Rezoning Transportation Analysis

Petition Number: 2020-173

General Location Identifier: Tax ID 02919113

Date	Description
12-28-20	First Review (EL)
1-21-21	Second Review (EL)

SCHEMATIC
SITE PLAN $20 \quad 0 \quad 20 \quad 40$
SCALE: 1" = 40'PROJECT #:887-004
JO
CHECKED BY:

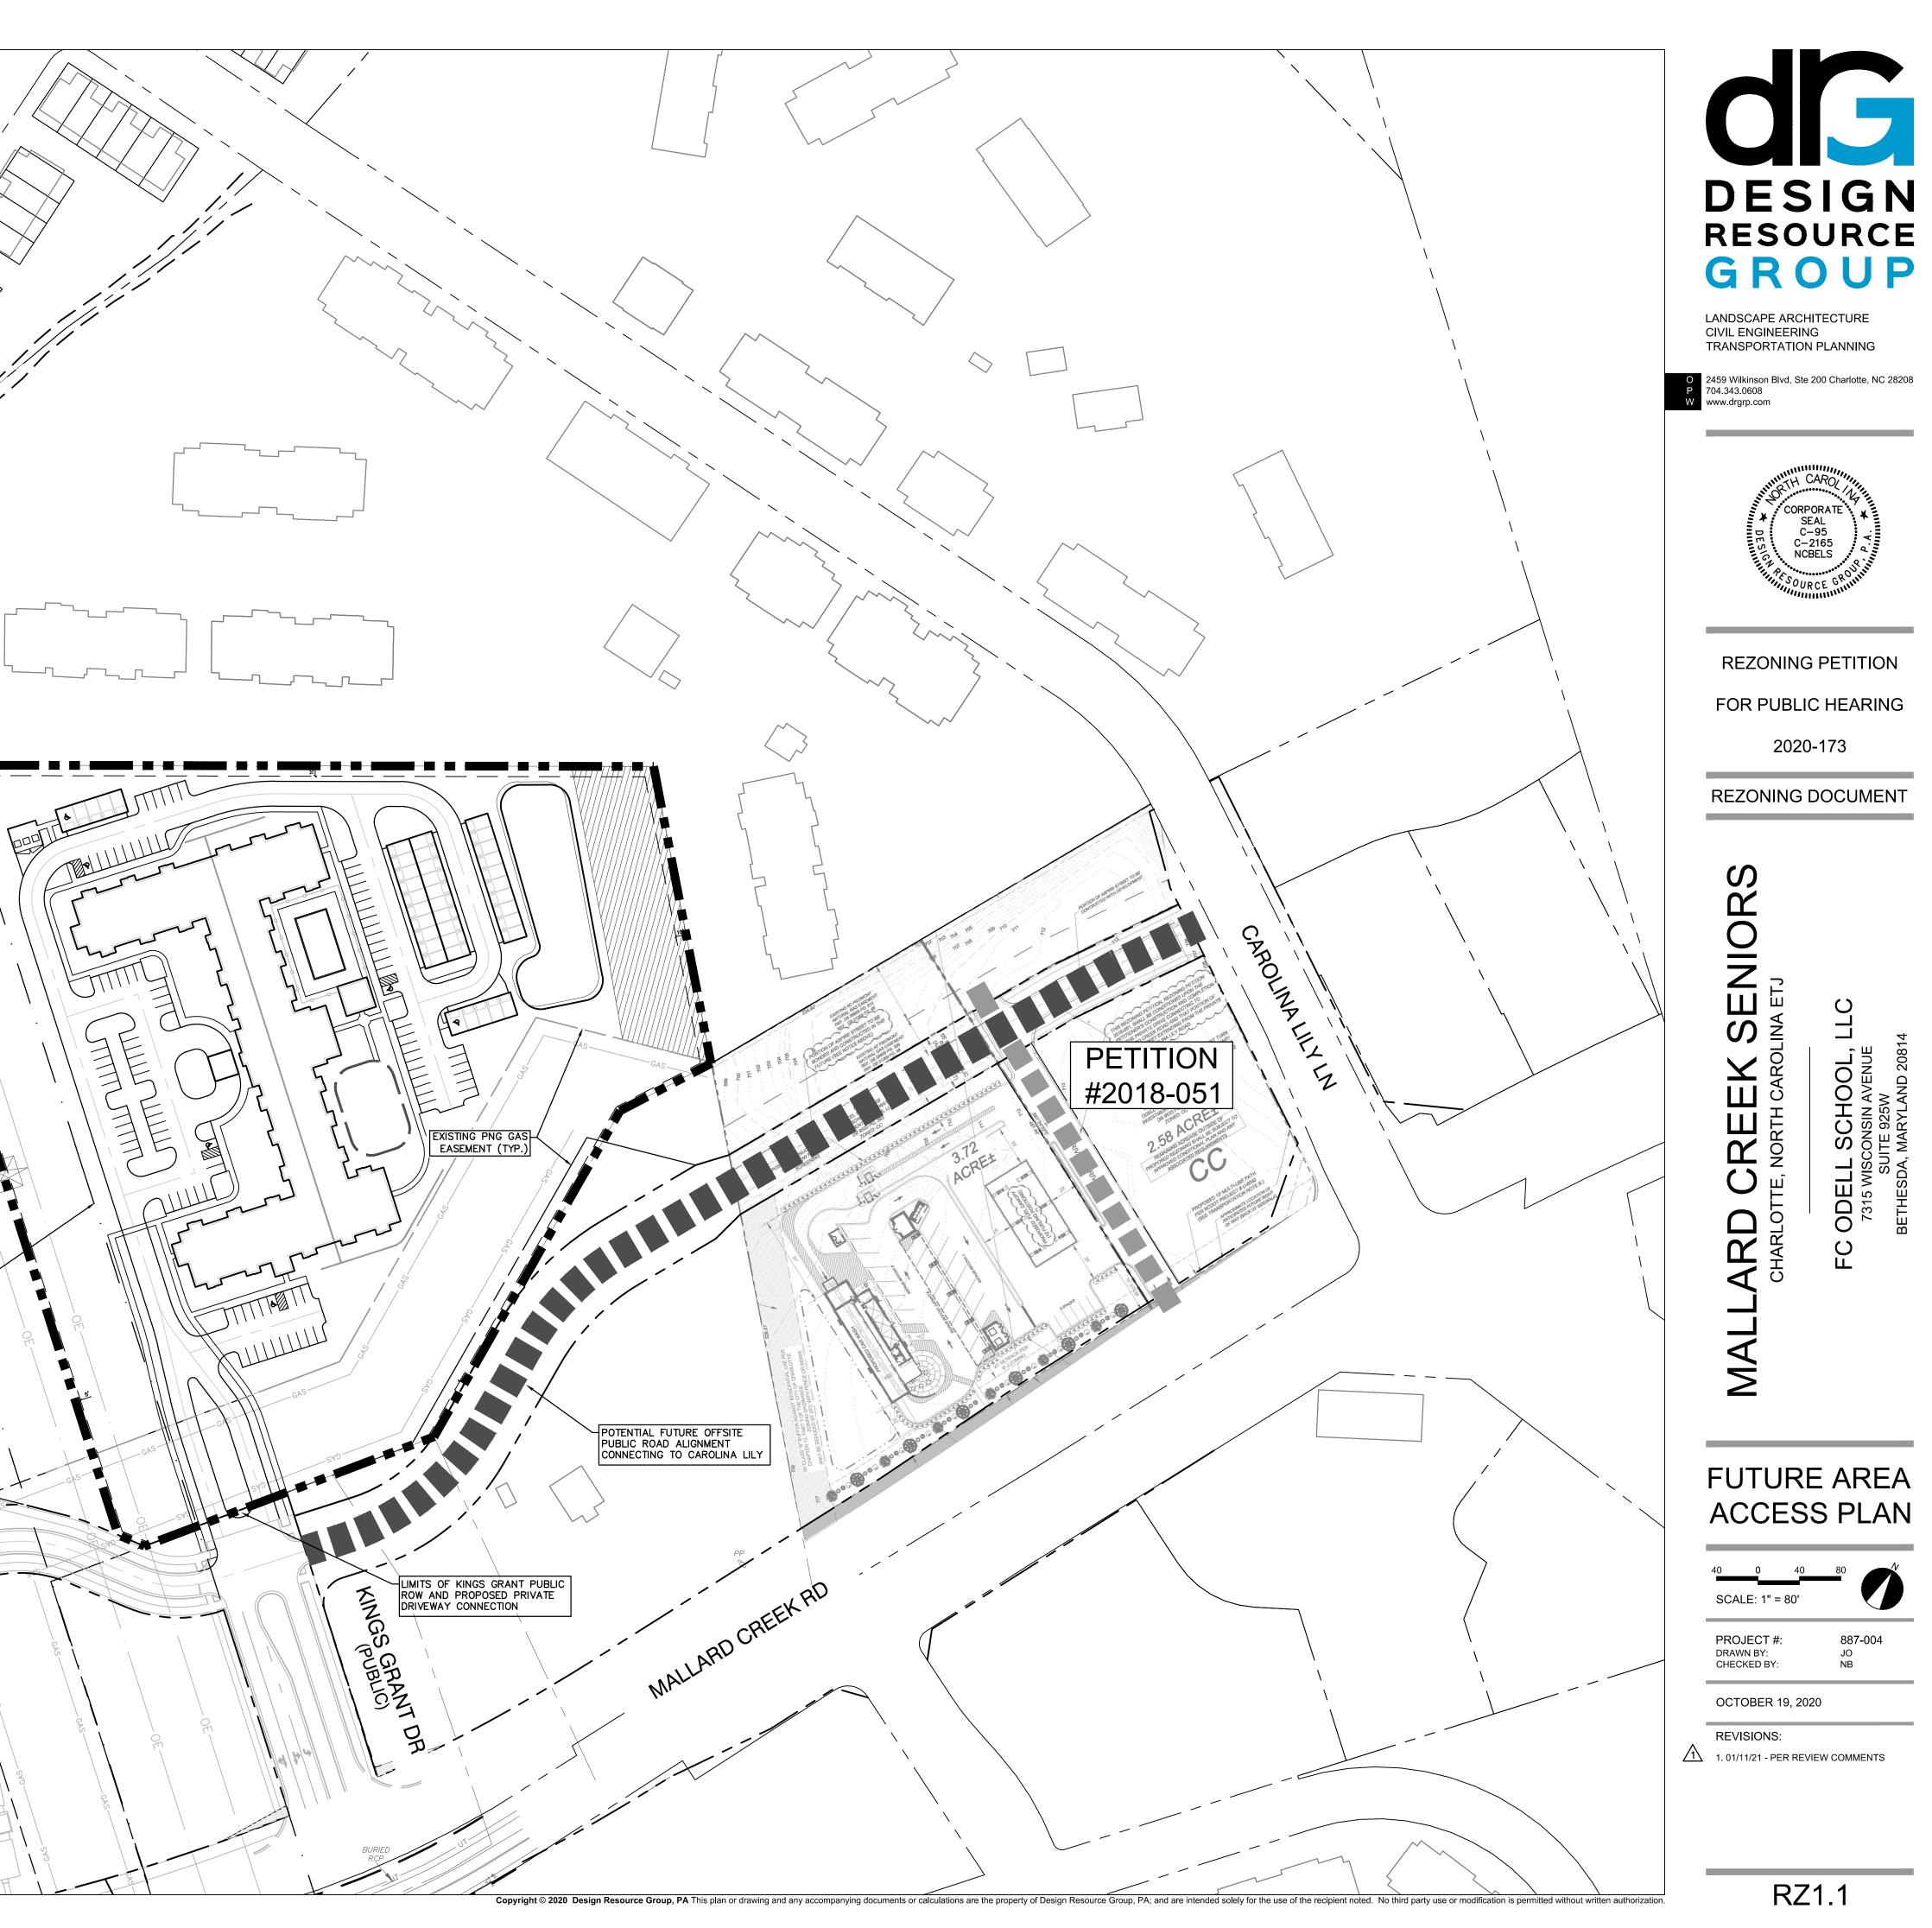
Outstanding (site plan dated 01/11/21) Unless otherwise determined by NCDOT to permit interim access to the full movement intersection of Mallard Creek Road and Kings Grant Drive, a Traffic Impact Study is not necessary for the complete review of this petition due to the site generating less than 2,500 daily trips. If during the permitting process the site generates more than 2,500 daily trips, then a traffic study will be required.

4. **Outstanding** (site plan dated 01/11/21) In coordination with NCDOT, revise site plan and conditional note(s) to clarify how the proposed access will be provided to this rezoning petition's landlocked parcel, if approved **SDRMF-2019-00075 - Mallard Creek Townhomes**, within **rezoning petition 2018-067**, is not developed to provide access off the proposed public Aspire Street.

Kings Grant Drive, north of Mallard Creek, will not tie-into Mallard Creek, since the NCDOT's State Transportation Improvement Program (STIP) U-6032 project has been delayed for construction until 2025. STIP U-6032's scope will improve the Kings Grant Drive and Mallard Creek Road intersection with a signal. Kings Grant Drive improvements, to be installed by **Mallard Creek Townhomes**, north of Mallard Creek Road, will stop short of Mallard Creek Road as an interim condition.

NCDOT will require interim improvements on Mallard Creek Road, if the petitioner desires access off Kings Grant Drive should the proposed Aspire Street not be constructed by others. CDOT recommends the petitioner to coordinate with NCDOT to determine the required interim improvements on Mallard Creek Road as a plan for this scenario.
